**KIRKLEES METROPOLITAN COUNCIL
DEVELOPMENT & MASTER PLANNING SERVICE**

**DELEGATED DECISION FOR PRIOR APPROVAL FOR CHANGE OF USE
FROM COMMERCIAL, BUSINESS AND SERVICE USES TO
DWELLINGHOUSES**

Reference no.	2025/CL/93525/E
Site Address	ground floor, 2, Bridge Street, Batley, WF17 5NU
Description	Prior notification for change of use from commercial/business/service to 4 dwellings
Recommending Officer	Elenya Jackson

DECISION - REFUSED

(EXISTING)(NORTH EAST) SIDE ELEVATION, 1: 100mm

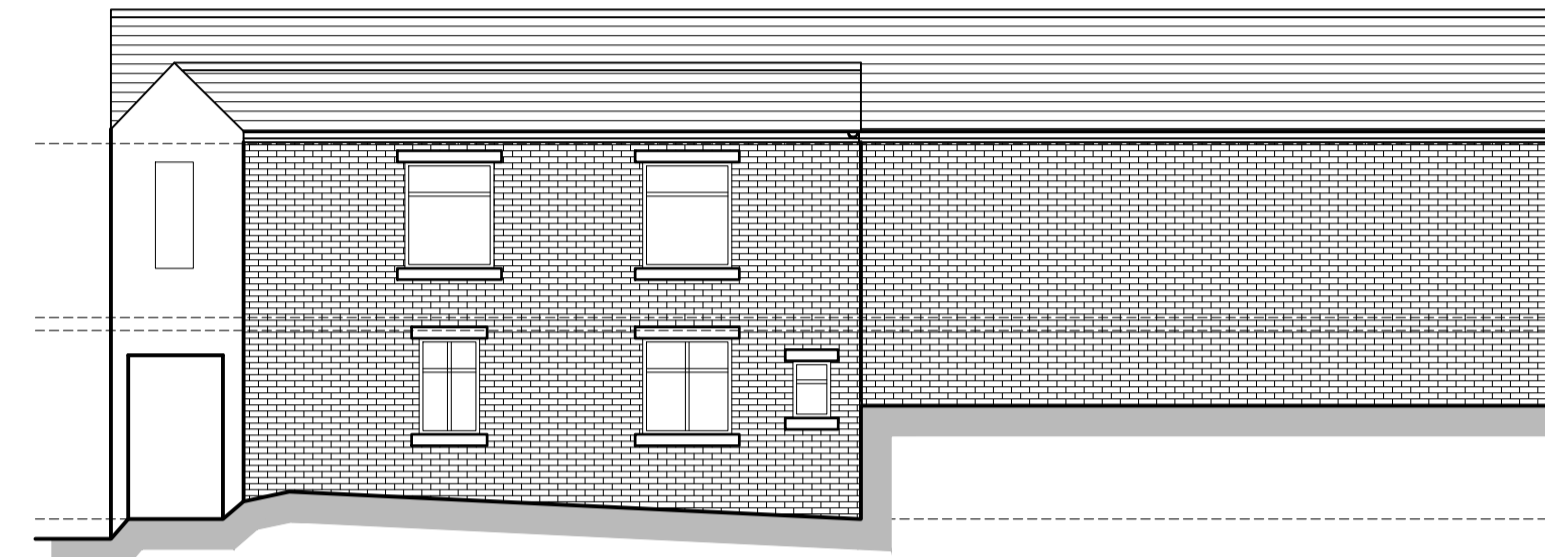
Equally, the existing doors in to the ground floor east elevation are solid with the proposed lounge and kitchen of this flat directly behind. Whilst there is a small existing window in the north east elevation serving the lounge , it is considered to be too small to allow light to sufficiently penetrate the kitchen dining area.

(PROPOSED) GROUND FLOOR PLAN

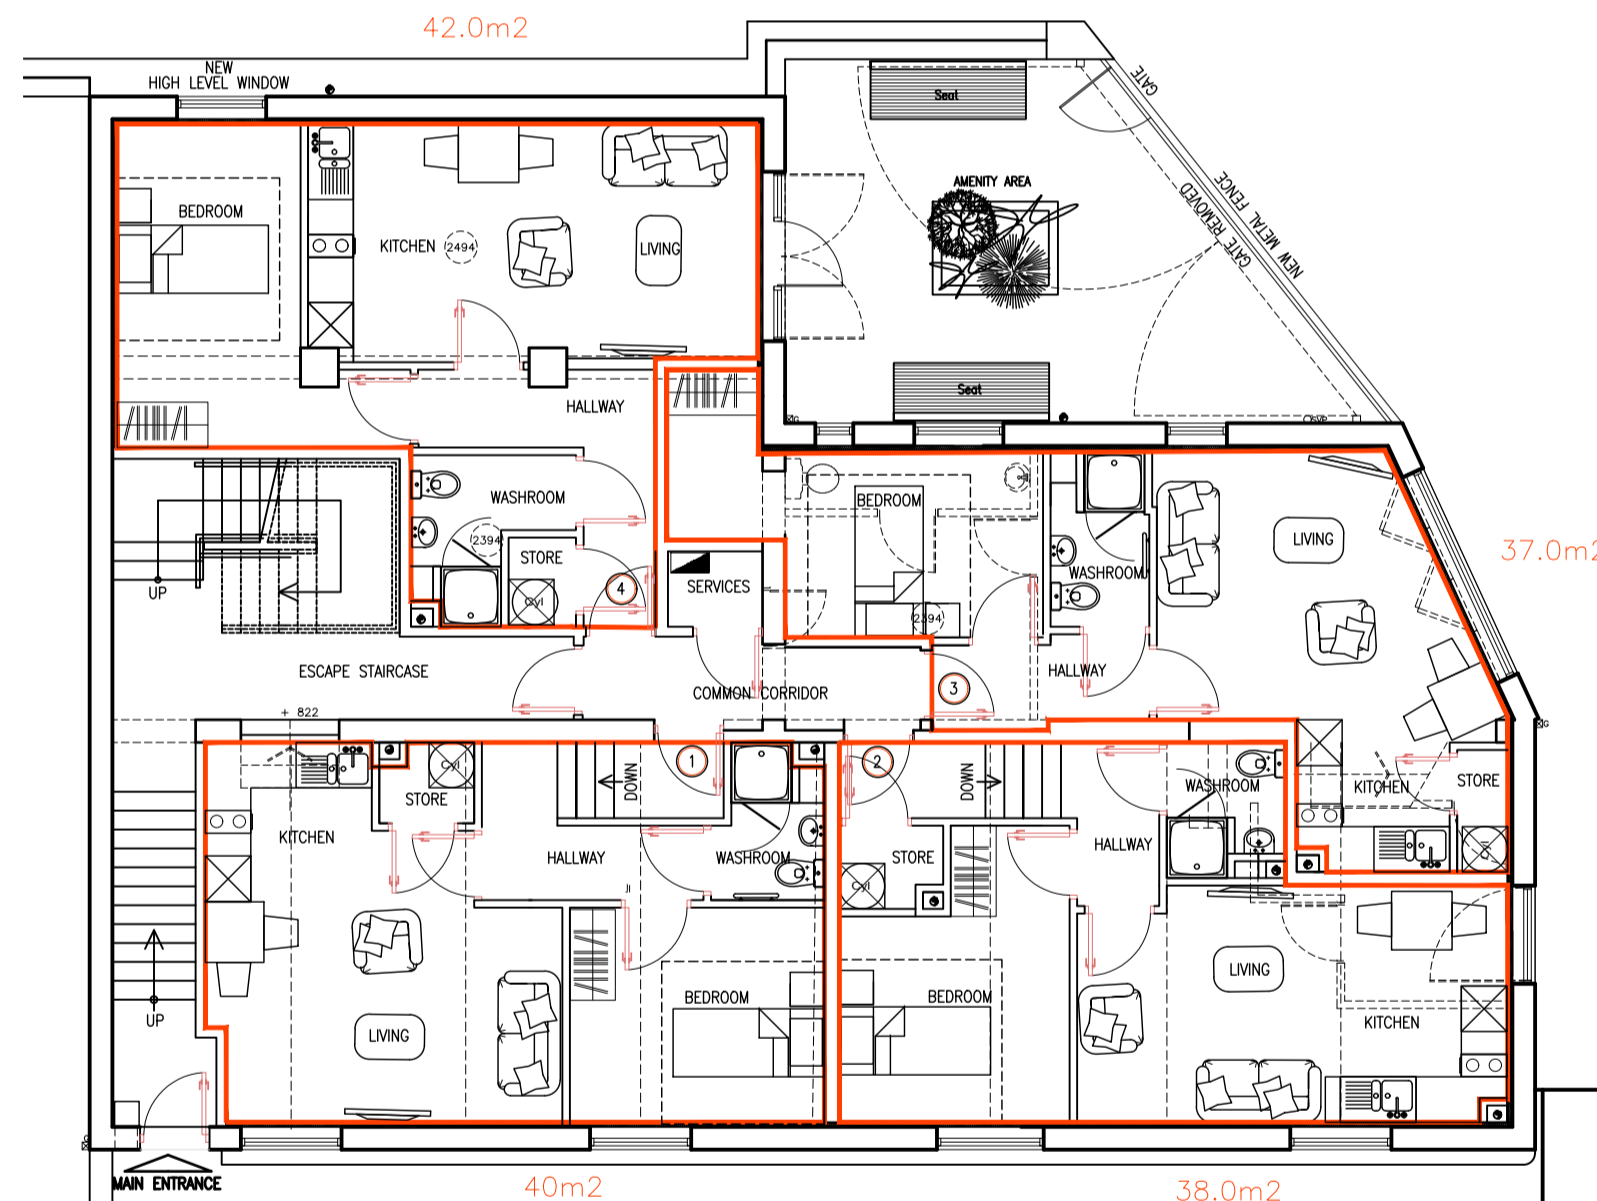
The submitted floor plans demonstrate that most habitable rooms will be served by at least one window with bedroom 1 served by two windows to the front of the building. However, the submitted floor plans indicate that the bedroom within the north east flat is to be served by a "new high level window" which currently does not exist. As no planning permission or permitted development rights have been demonstrated, this bedroom would not benefit from any natural light.

It is considered that not all habitable room windows will receive adequate natural light, particularly the absence of any existing window in the bedroom of the flat located in the north east corner of the ground floor and insufficient light penetrating into the living/kitchen/dining area in the flat located behind the existing solid doors on the east elevation.
